Application # 0750018052R

COUNTY OF HARNETT LAND USE APPLICATION

**Re: Status of Improvement Permit Application #07-5-18052 Lt 252**

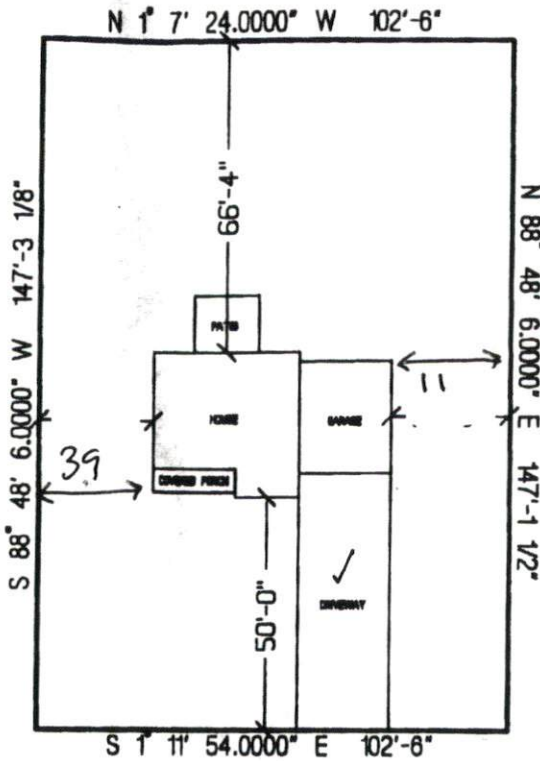
- 1. Property lines/corners not marked or labeled
- 2. House corners not marked or labeled
- 3. Directions not clear to property
- 4. Property needs brush or vegetation removed
- 5. Backhoe pits required
- 6. Other – Please move house as shown on attached sheet, and submit new plot plan to Central Permitting.
